From: [REDACTED]
Sent: 24 November 2025 17:28
To: Simon Davis <Simon.Davis@arun.gov.uk>
Subject: Objection to AL/107/25/PL

Please would you register this as an objection to planning application AL/107/25/PL.

DRAWING TITLE  
 Proposed Elevations

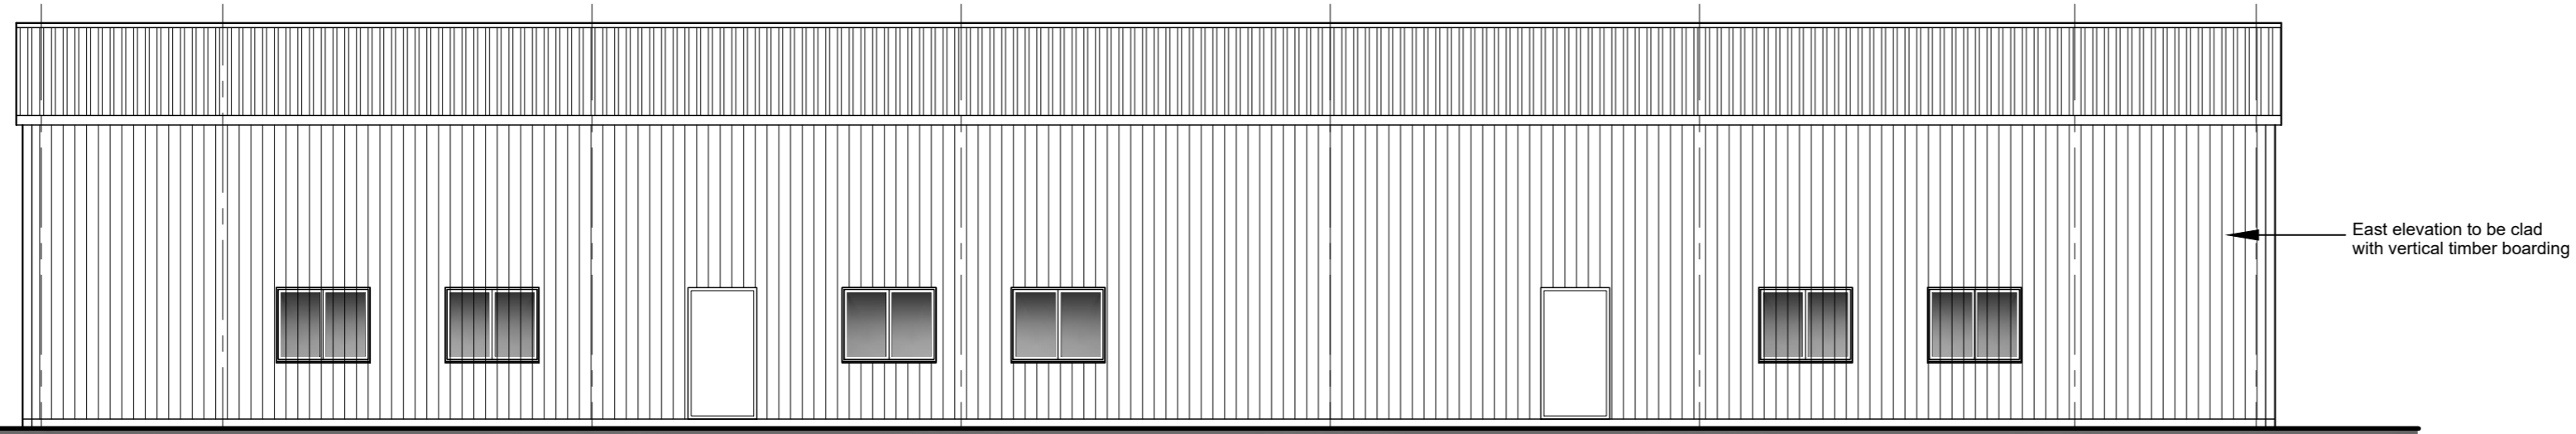
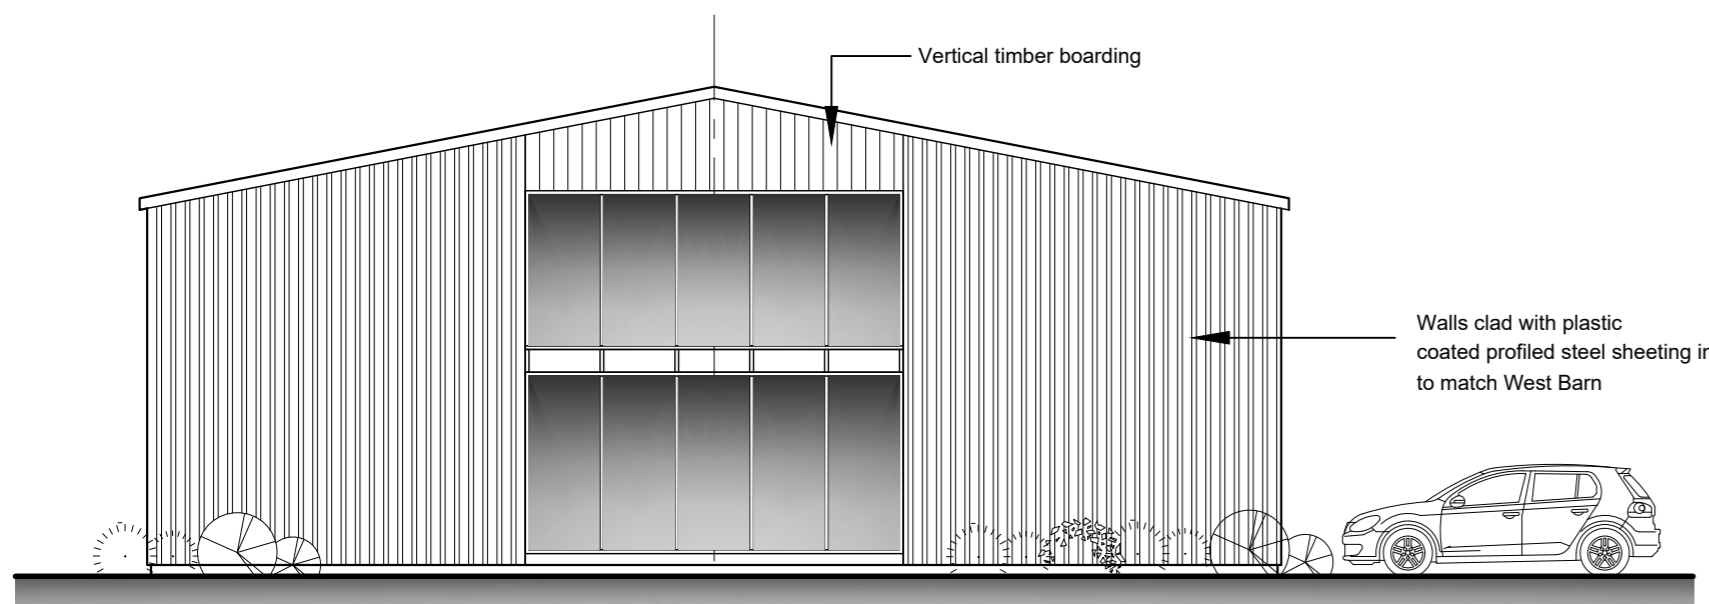
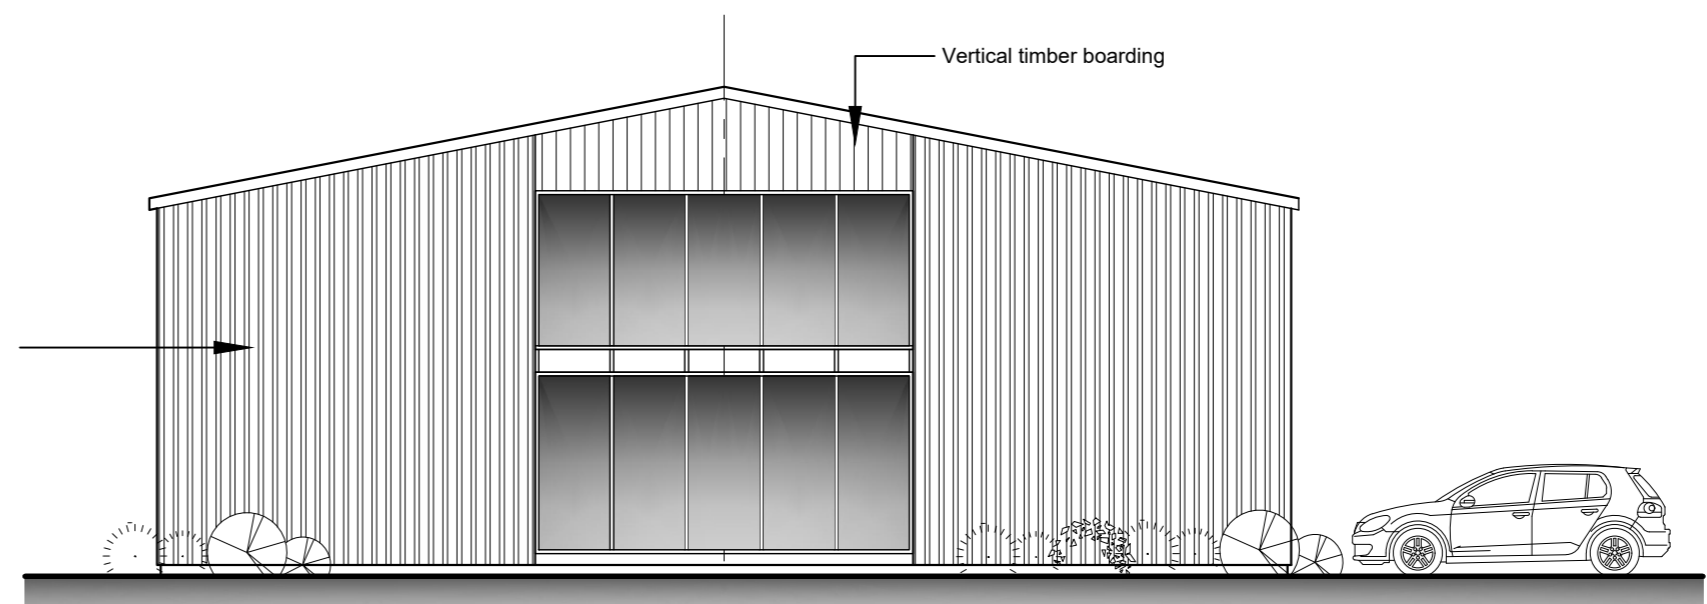
The proposed barn will be located approx. 8m due south from the rear boundary of The Old Stables, a single-storey dwelling. The proposed barn would be approx. 8m high with large glazed elevation directly looking into The Old Stables. The proposed barn with or without these windows would have an overbearing presence and overshadowing on the main living rooms of the property together with the private rear garden of the property. This

will severely affect the residential amenities and create an unneighbourly development completely out of character in the Conservation Area and so close to residential properties. The Old Stables would be in the shade for most of the year given the height and proximity of this proposed development

What if there is a fire, the building being only 8m away together with being 8m in height? This barn could be used for anything, no guarantee that Biodot will be the end users and no guarantee as to what is stored within the building.

Block Plan

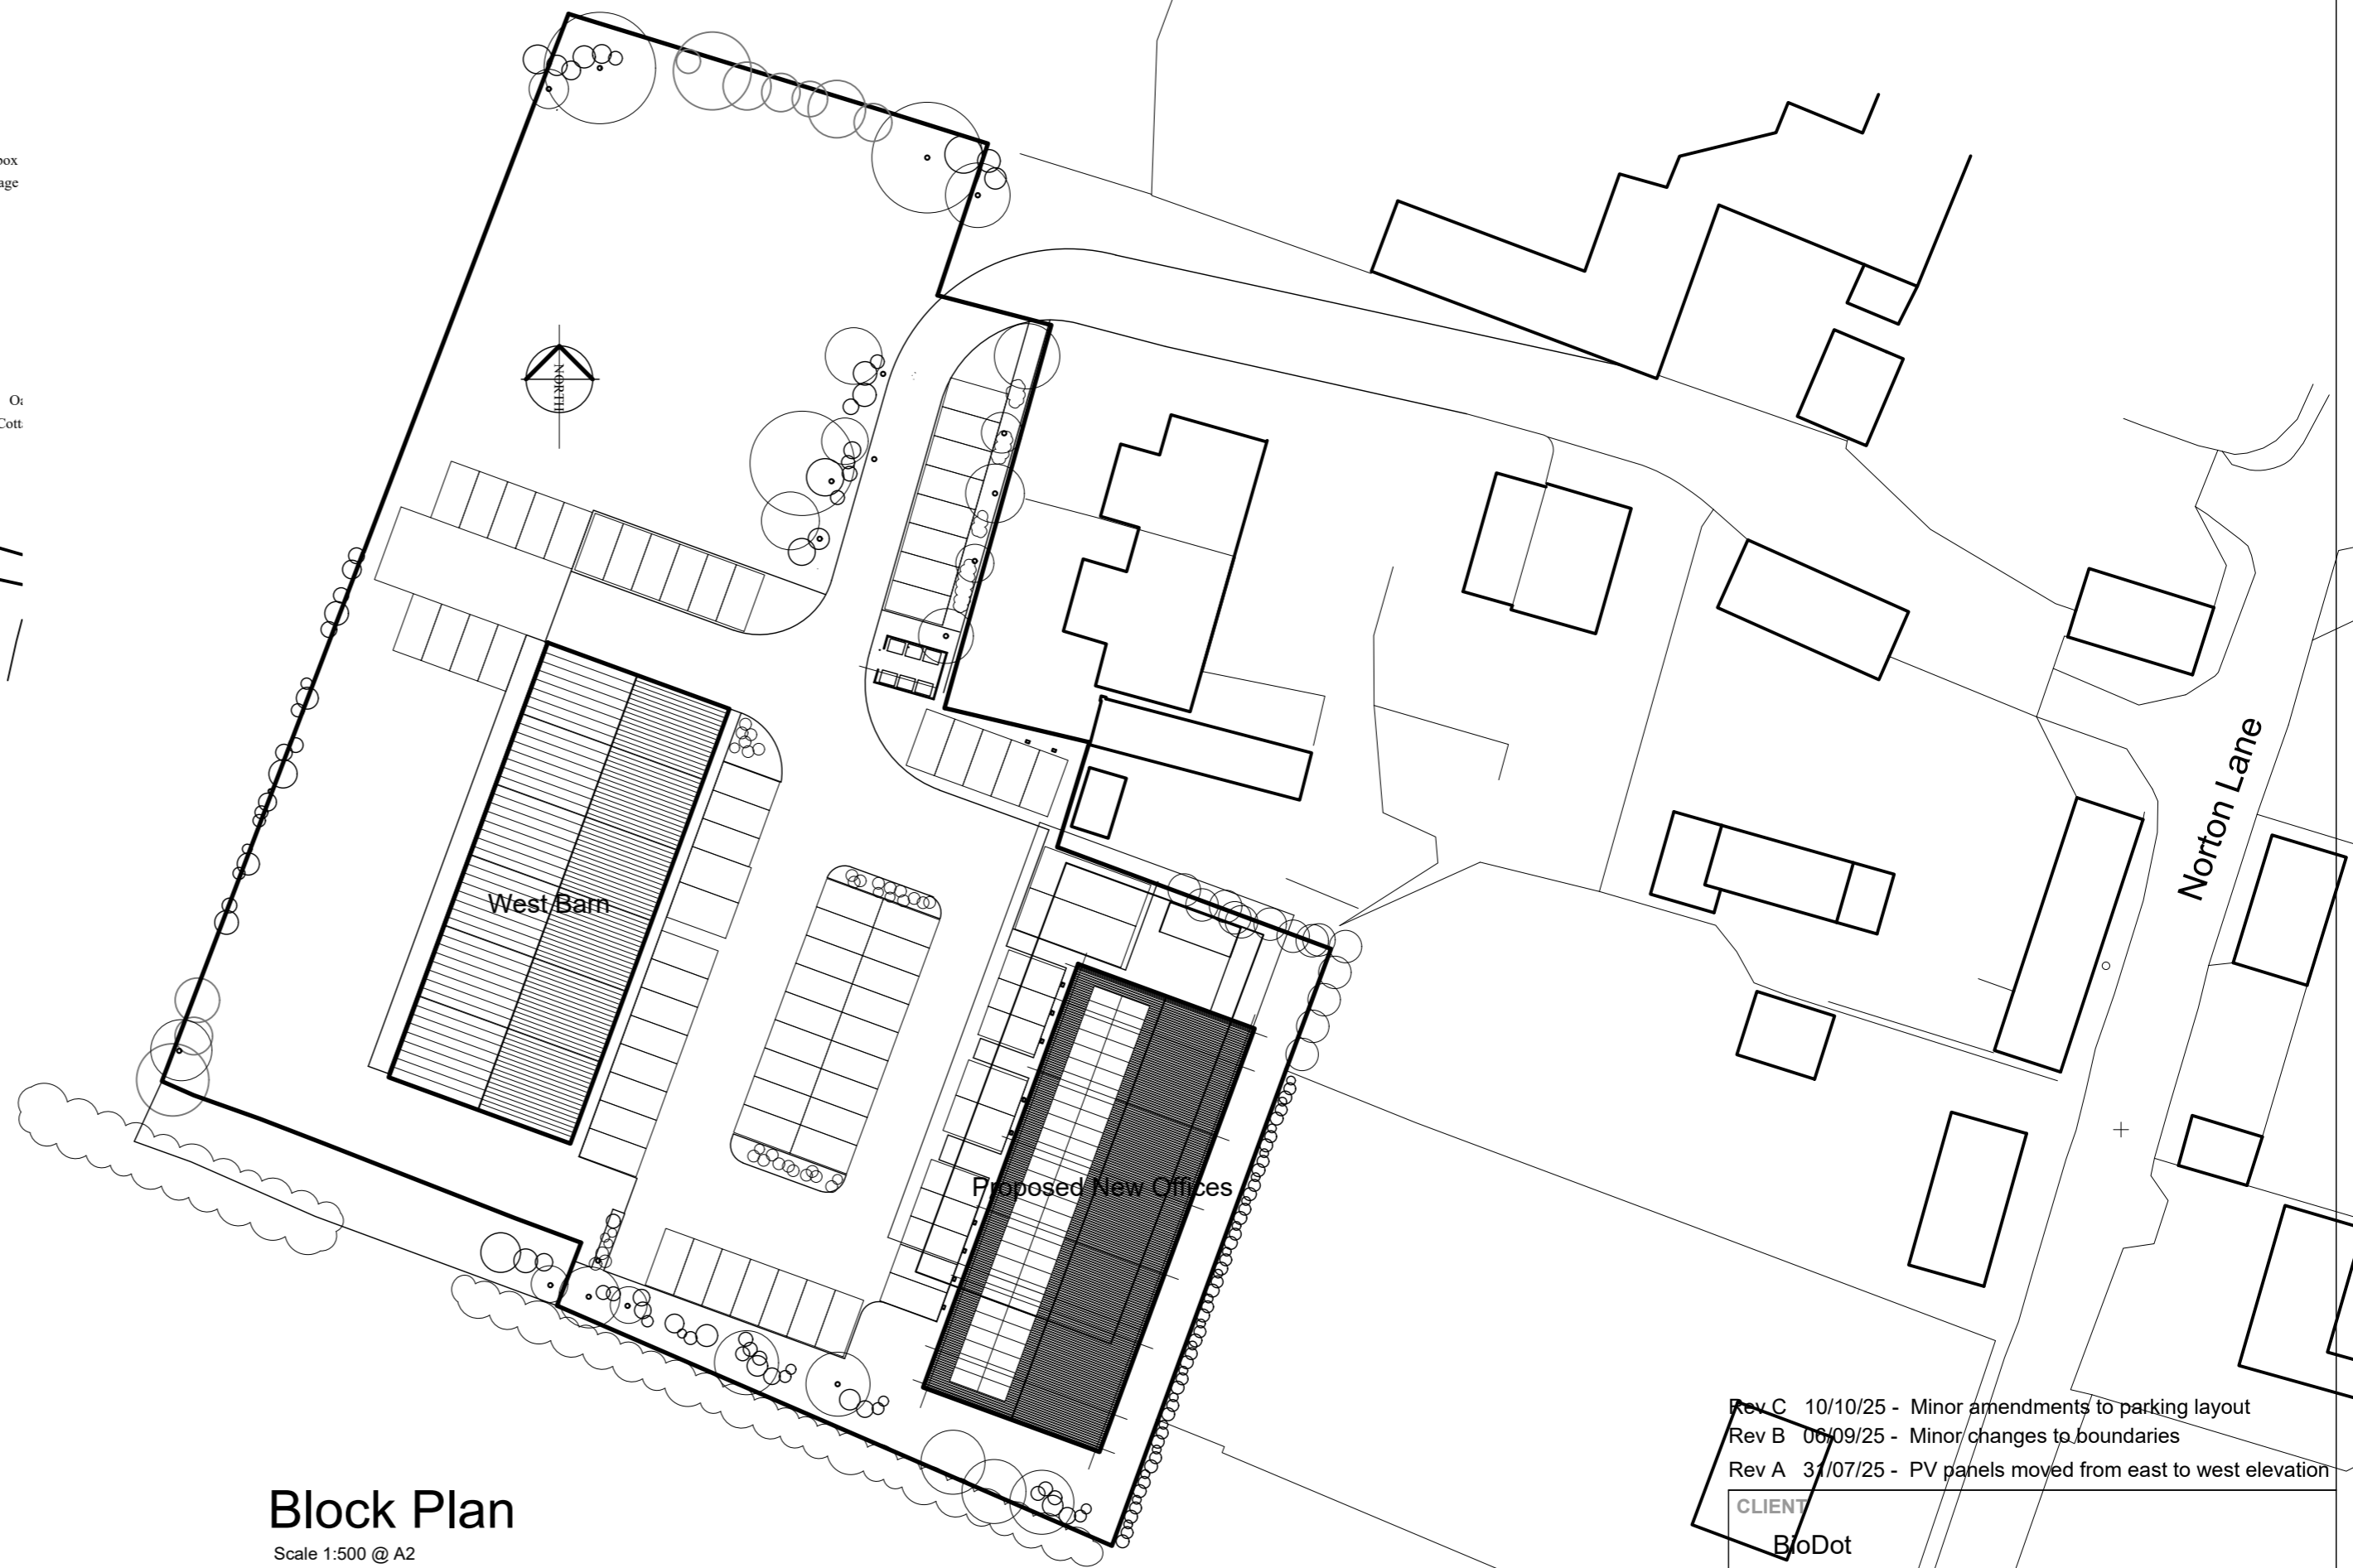
The Proposed Site Plan shows all the following points will be a nuisance, annoyance & disturbance;

- LGV Parking is situated alongside the fence which provides privacy for The Old Stables. Drivers are high up and will be able to look into the garden creating continuous & constant privacy, security & disturbance risk. Engines running, doors slamming, music blaring, telephone conversations, etc.
- Secure cycle storage is situated alongside the same fence, we all know that this is really an area for smokers as no one will use the cycle shed for cycles. So then along having the issues of LGV parking there will be the risk of continuous smokers' smoke, vaping and chatting coming over the fence
- Electric vehicle charging points, what about the fire risk and white noise that this will create?

The proposed plans show 40 parking spaces (in addition to the 40 already there), I feel that the Transport Statement and the Travel Plan are seriously misleading and incorrect. If this application was successful under full occupancy the traffic movements would be hugely greater having a major impact in the Conservation Area and to the residential properties. The Transport Statement quotes that people already cycle to the offices but to my knowledge no-one cycles there at present even though there are local people employed by Biodot.
